DEVIATION REQUEST AND DECISION FORM

Project Name : Crossroads North

A deviation from the standards of or in Section 2.3.7.E.2 of the Engineering Criteria Manual (ECM) is requested.

The requested deviation is for left turn lane length criteria (ECM Standard 2.3.7.E.2 & 3)

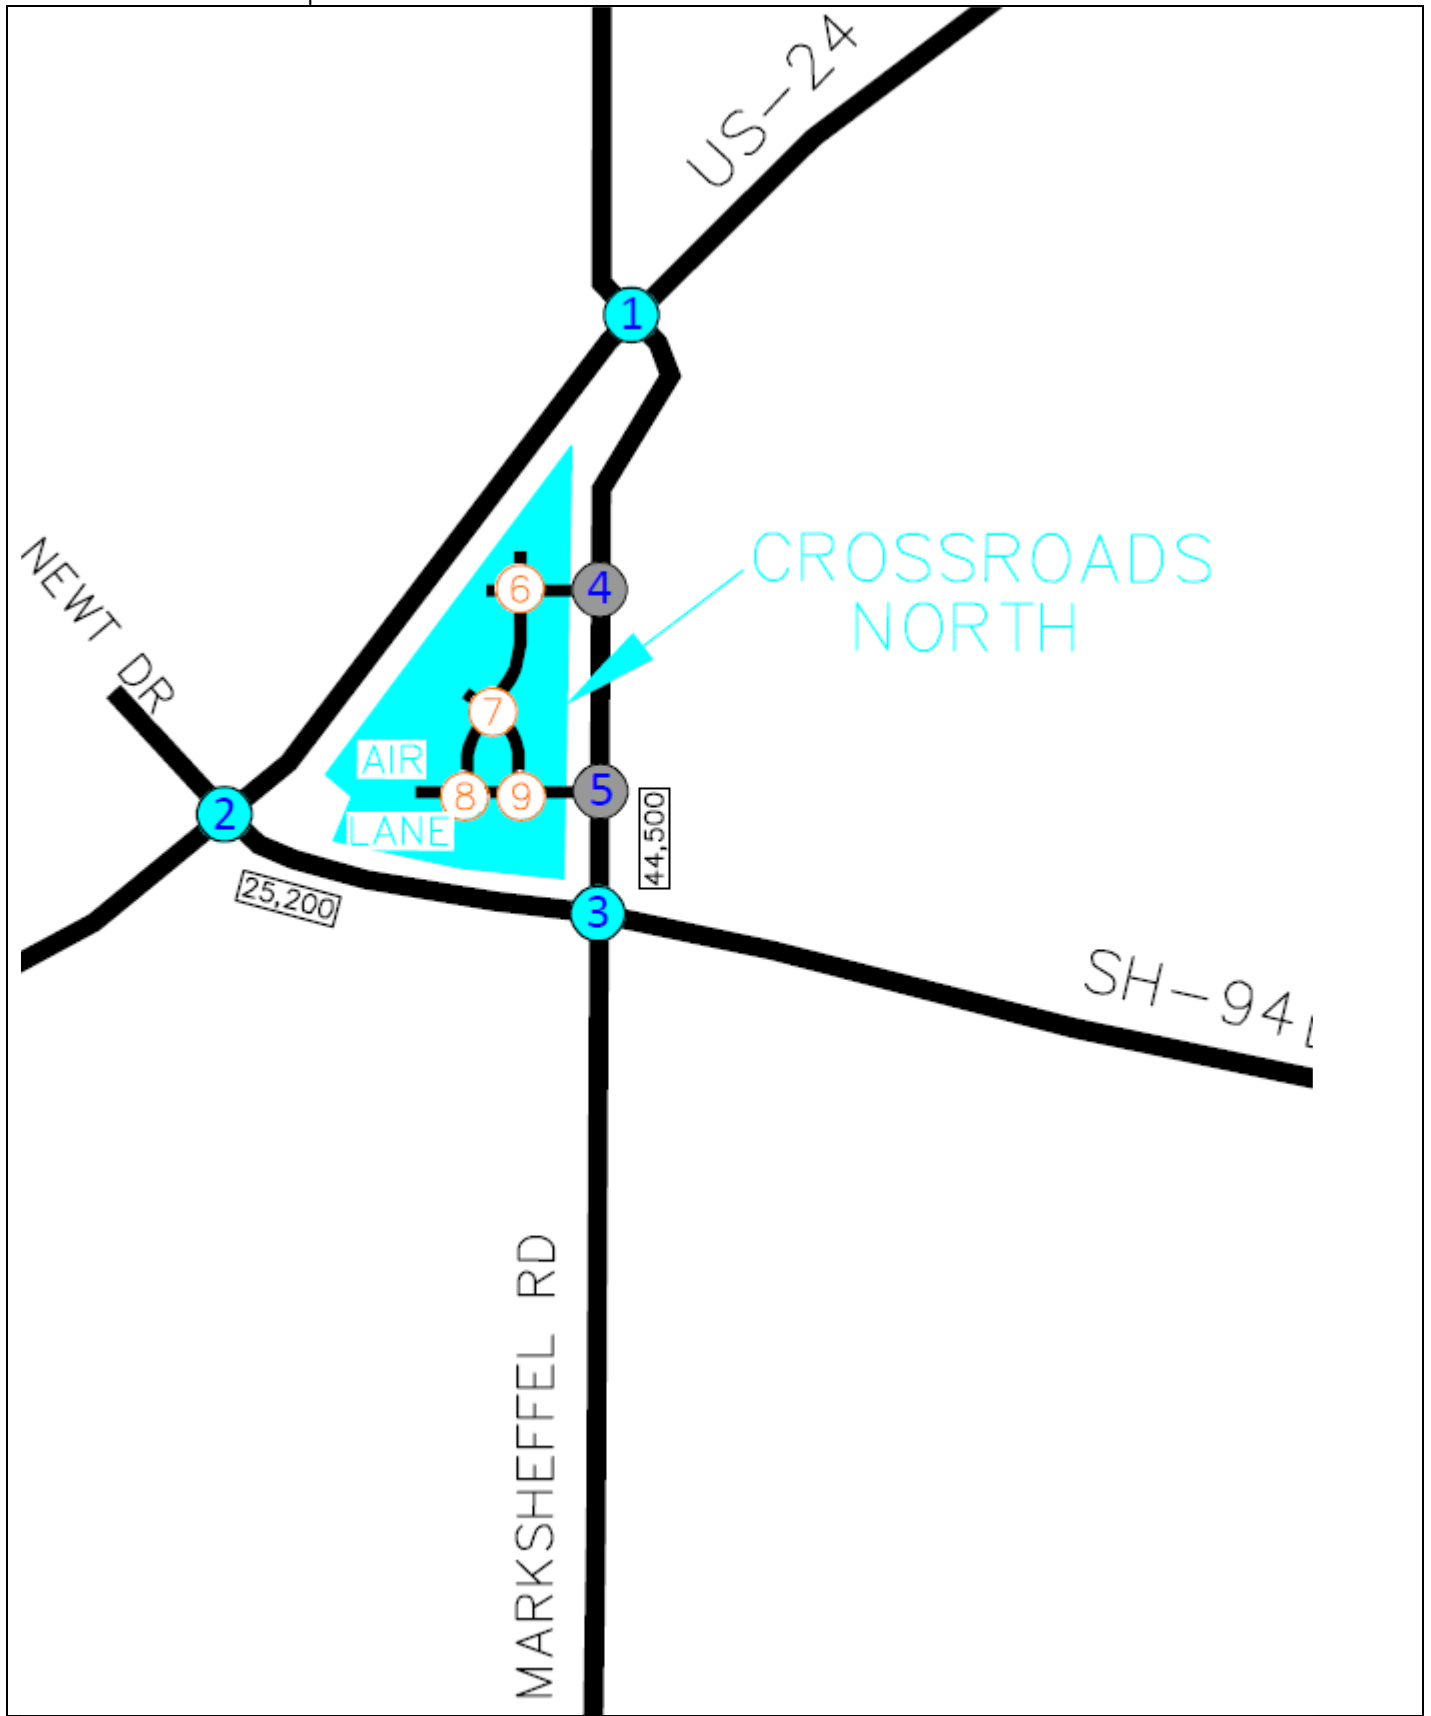
Deviation request will be denied based on City of Colorado Springs comments to design the north access as unsignalized 3/4 movement. Staff recommend withdrawing the deviation request.

3/4 movement will not require a back to back left turns at this intersection (access #4)

The city of Colorado springs require the development to design the north proposed site access (access #4 in the TIA) as unsignalized 3/4 movements intersection, and the proposed south site access (access #5 in the TIA) as signalized full movement intersection.
